UNSW RESPONSE TO THE CBD AND SOUTH EAST LIGHT RAIL (CSELR) ENVIRONMENTAL IMPACT STATEMENT

Refer also to the JBA 'Submission on CBD & south-East Light Rail Project' submitted on behalf of the Univeristy of NSW

UNSW Anzac Parade Stop -  
Current and Future Service  
Provisions

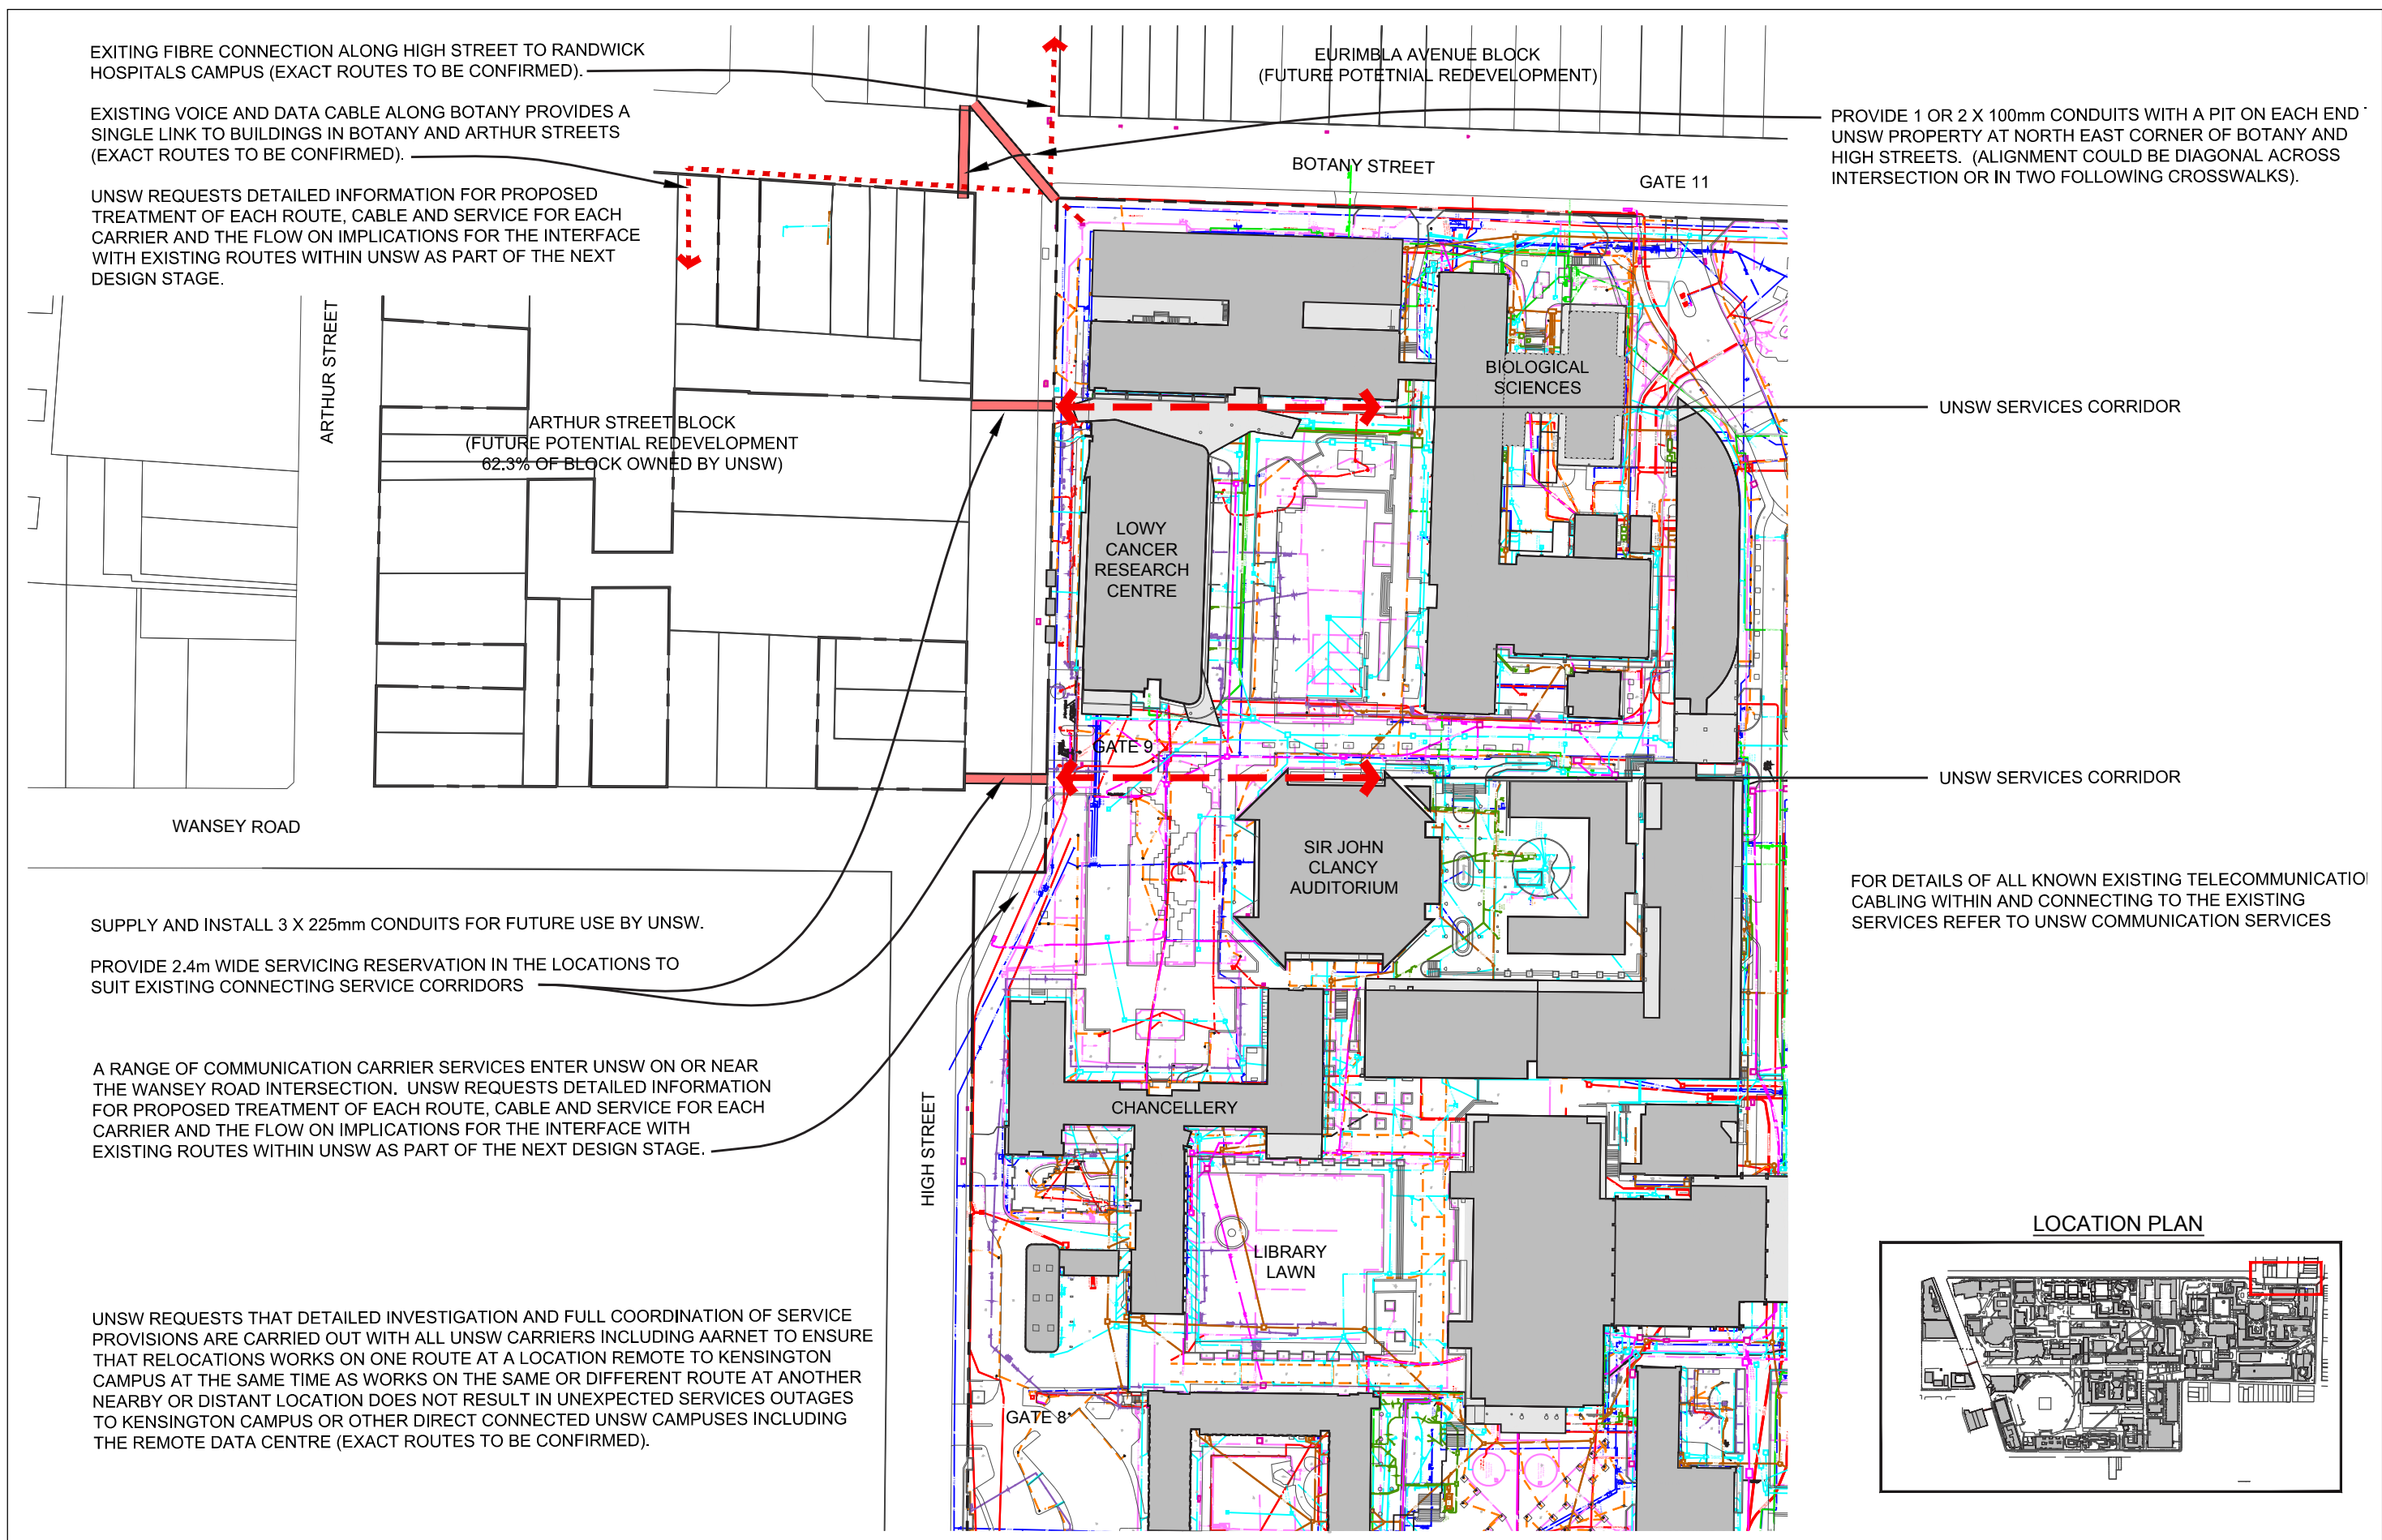
EIS Document	Page # in EIS Document	Section #/Table #/Figure #	Comment
Part C: Regional environmental impact assessment. Chapter 10 Other regional impacts	10-56	Figure 10.8 Typical treatment zones for utilities under the propose CSELR alignment	The impact zones along the UNSW campus boundary adjacent to Anzac Pde between High Street and Barker Street contains underground potable water pipework and valves serving UNSW buildings. UNSW has a significant amount of large stormwater pipework, drains and pits serving the immediate buildings as well as the wider campus. UNSW also has several hydrant booster points including both underground services and surface installations for fire fighting, plus trade waste infrastructure serving the Square House consisting of pipework, pits and control and monitoring equipment. This infrastructure is critical to UNSW's ongoing operations and maintaining service. Relocating the infrastructure outside the impact zones is critical.

CBD & South East Light Rail Project  
EIS Response for UNSW  
UNSW ANZAC PDE STOP  
LANDSCAPE AND GROUNDPLANE PLAN

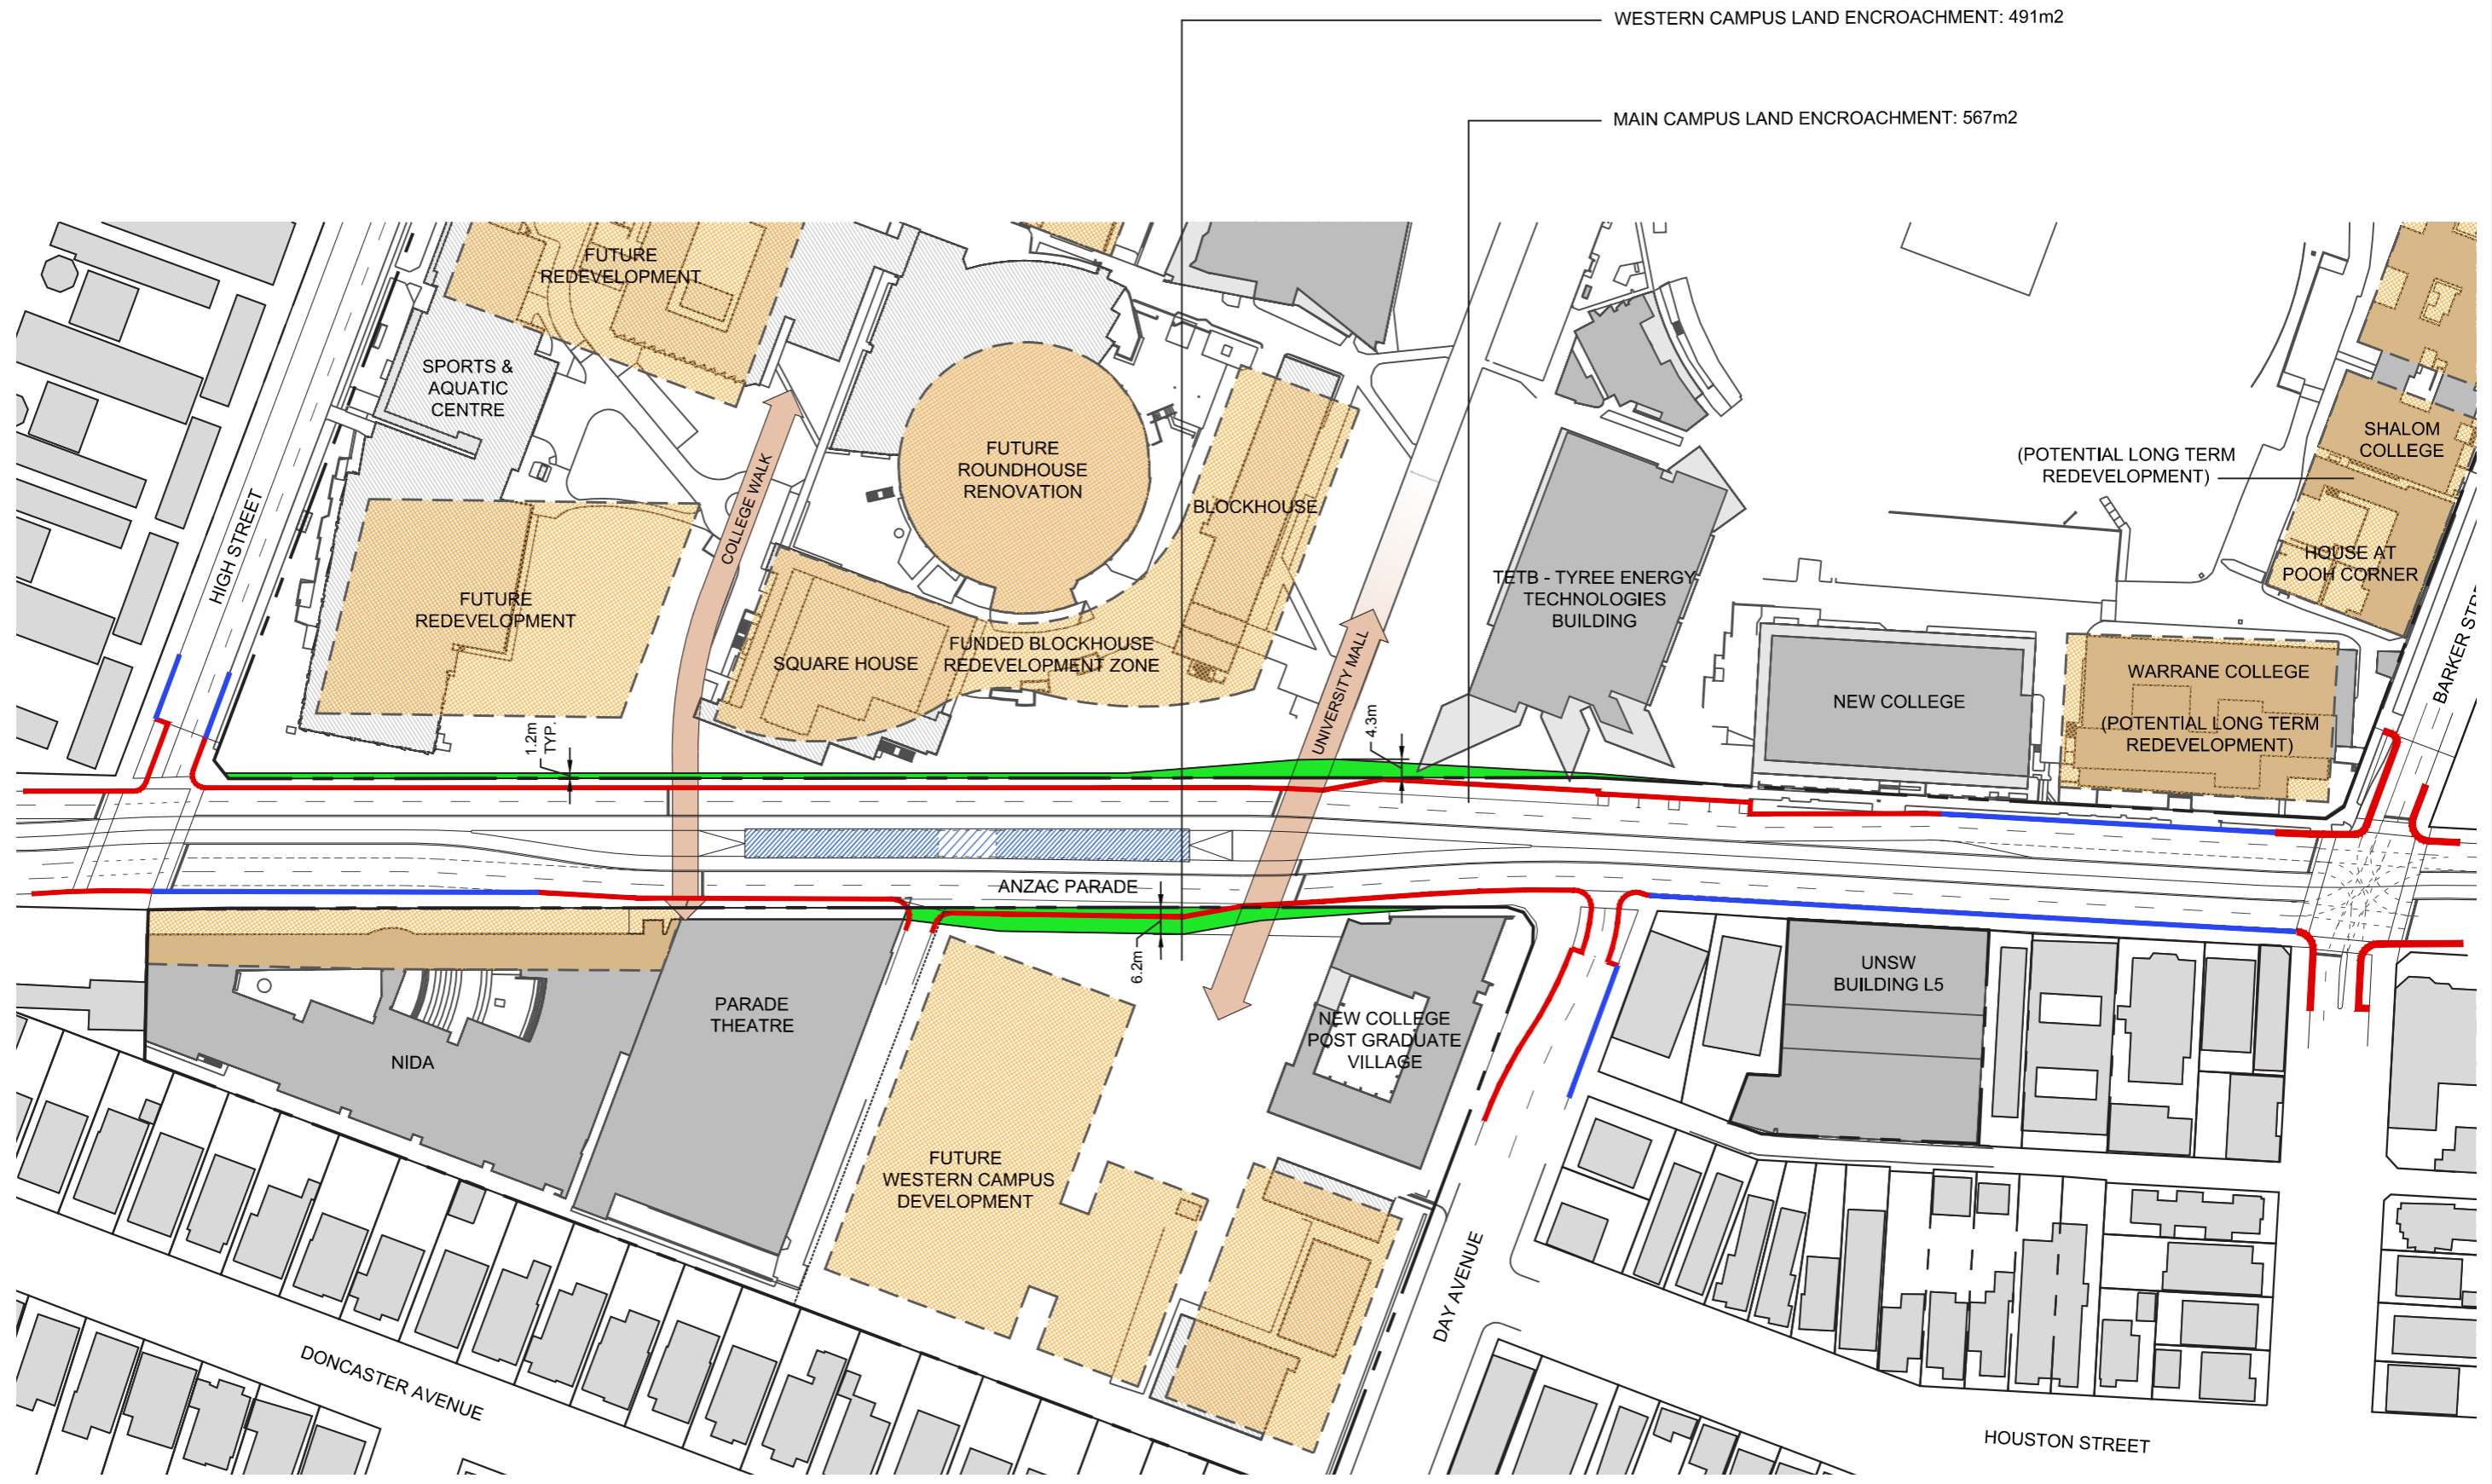
EIS Document	Page # in EIS Document	Section #/Table #/Figure #	Comment
Part B: The proposal & its development. Chapter 5 Proposed infrastructure & operations	5-52 & 5-53	Figure 5.39 Indicative section - UNSW Anzac Parade stop & Figure 5.40 Indicative plan - UNSW Anzac Parade stop	<p>The side running track on UNSW land is not supported and it should be changed to a centre running track with an island platform so as to avoid loss of UNSW land, relocation of underground services, removal of significant trees and landscaping along the campus frontage. The preservation and maintenance of all significant fig trees along Anzac Parade in the vicinity of the UNSW campus is considered essential to preserve the amenity and character of the campus. No tree replacement strategy is provided. Further discussion with UNSW is required as to how pedestrians, cyclists and buses will be managed at this stop. UNSW trade waste, water supply bores and associated reticulation and stormwater will be affected. More specifically, existing underground services include:</p> <ul style="list-style-type: none"> * Location of two of the three large water production bores and associated services for the city of Kensington Campus which draws some 200kL / day of groundwater for 'commercial' uses, * UNSW main stormwater pipeline runs within part of this strip of land, * Bore water reticulation drain point lies immediately beneath the platform. * Irrigation pipelines run the length of the proposed land acquisition. * Trade waste grease arrester and associated sewer drainage. * Bore water mains exist across Anzac Parade to provide supply to Western Campus and to L5 site. <p>Substantial relocation of stormwater services will be required to remove them from the acquired land.</p>

5-69	5.2.9 Street trees	This section does not address the existing significant trees on Anzac Pde between High Street and Barker Street along the campus frontage.
	5-74	Table 5.2 Permanent land acquisitions	Permanent land acquisition of UNSW land at the UNSW Anzac Parade stop is not supported because the side running track on UNSW land is not supported (see comments above re pages 4-23 and 5-52).
	5-75	Table 5.3 Temporary leases for construction	The temporary lease of UNSW land off Anzac Parade is not supported because the need for a construction compound in on the UNSW campus is not supported. The location of a compound on the lower campus will require the relocation of UNSW underground services, removal of trees, landscaping and lawn and adversely affect pedestrian routes and teaching. The underground services will be inaccessible for repairs and maintenance and may also be damaged during construction due to ground settlement and compaction. The UNSW overland stormwater flood path drains onto Anzac Parade across the proposed construction compound.
